From: Michael Eastham
Sent: 10 January 2018 08:18
To: Planning.Responses
Subject: FW: BN/28/17/RES - The former Lillies Caravan Park, Barnham

From: Sue Howell
Sent: 09 January 2018 16:42
To: Michael Eastham
Subject: RE: BN/28/17/RES - The former Lillies Caravan Park, Barnham

From: Sue Howell
Sent: 03 January 2018 17:15
To: Michael Eastham
Subject: RE: BN/28/17/RES - The former Lillies Caravan Park, Barnham

scheme: The Lillies, Yapton Rd
Barnham
client: Matthew Homes
drawing: Landscape Proposals
date: April 2017
scale: 1:200@A1
drawing no: MAT21212 11E sheet 2
drawn: AE checked: DKM

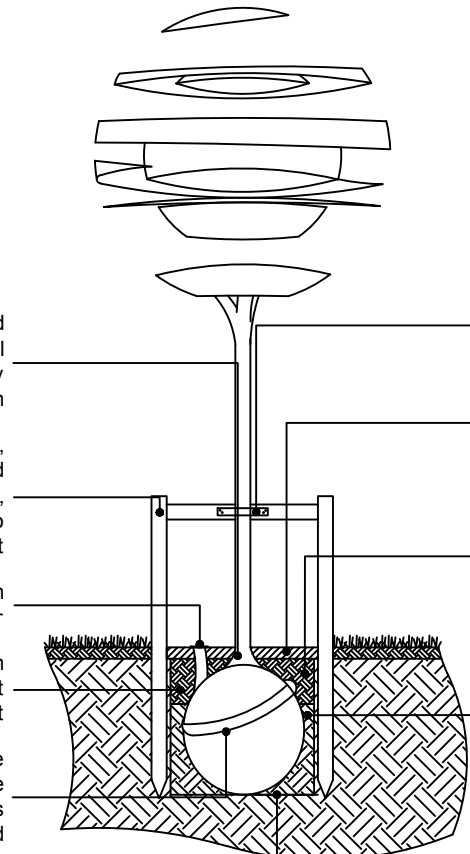
- The repositioning of Block A I feel has just shifted the issue not resolved it. The omission of Block A would be a better outcome.
- The drawing MAT21212 11E Sheet 2 now details Informal play space adjacent to the SuDS depression. The requirement for this site regarding play is for on-site LEAP, detail of this has still not been provided or detail of such specified ('informal play' annotation does not provide this detail) Please therefore ask for the detail of the play offer detail; as previously requested below, to be provided.

1. The depth of the attenuation feature is driven by the invert level of the existing ditch to which the surface water discharges. Therefore, there is no option to deepen the depression and reduce its footprint. With regard to the usability of this space in dry spells this is a matter of detailed design. The base of the depression will need to be underlain with free draining material. This should ensure that the area drains/dries quickly as the water level recedes.
2. Block A has been repositioned in a positive manner after discussions with the planning officer and his superiors, the location is now a much better all-round siting than previous and addresses the green space better and acts as a vista stop from the north and west.
3. There is no detail in the S106 agreement which specifies a LEAP has to be provided and thus the POS on this site is merely that.

scheme: The Lillies, Yapton Rd
 Barnham
 client: Matthew Homes
 drawing: Landscape Proposals
 date: April 2017
 scale: 1:200@A1
 drawing no: MAT21212 11E sheet 1
 drawn: AE checked: DKM

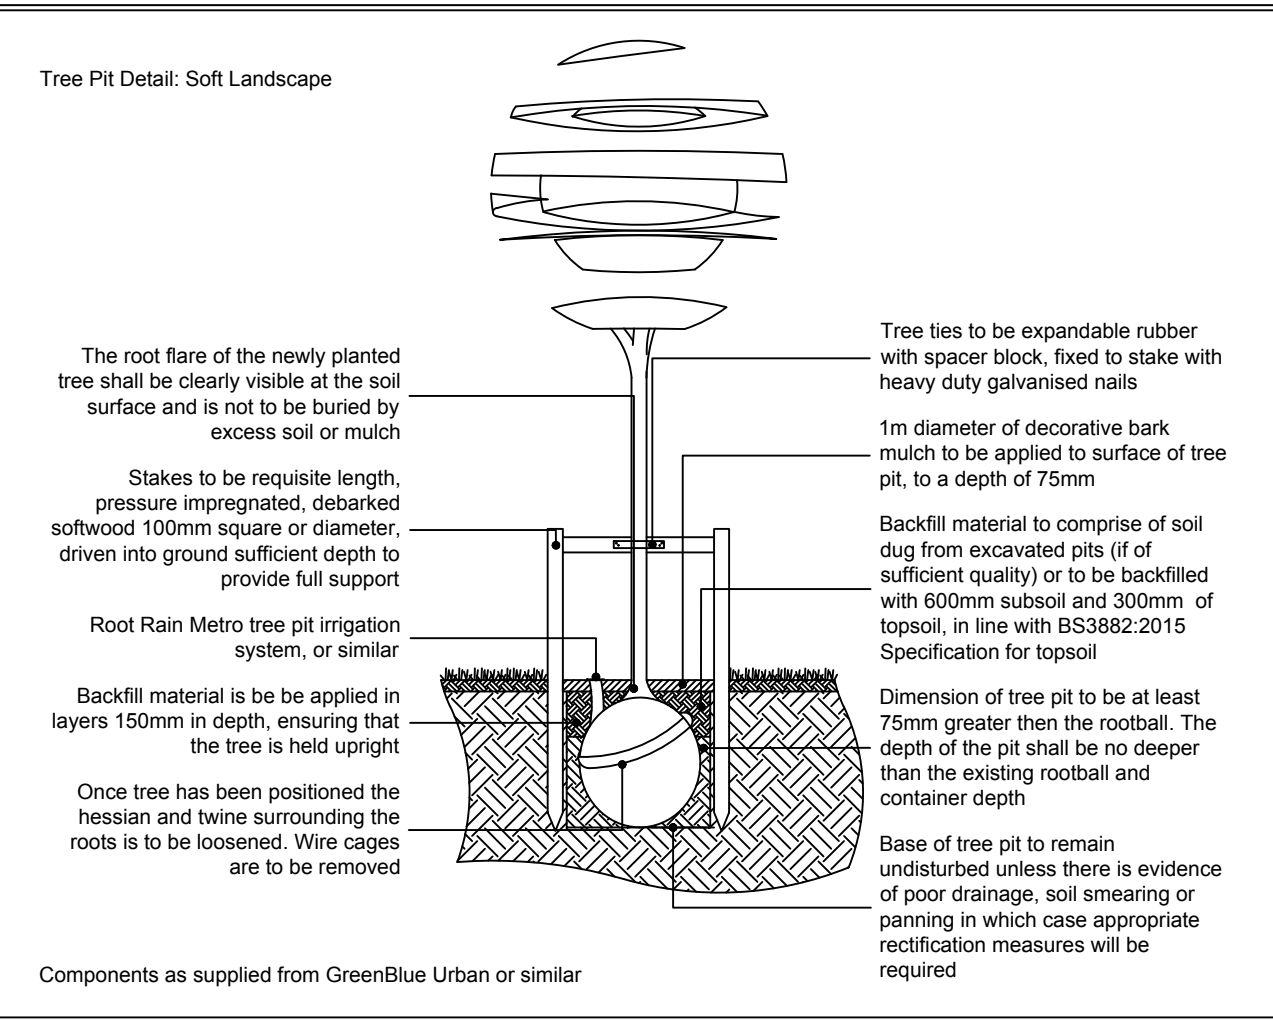
- I still remain to be convinced that a basin with a 1.0m depression taking the majority of the POS provides safe and useable POS? I would recommend that now that this detail has been supplied that it is run past our Drainage Engineers for their view on the 1 in 100 year storm event scenario and whether they concur that this area would otherwise remain dry in reality? I now refer this to them for an expert opinion.
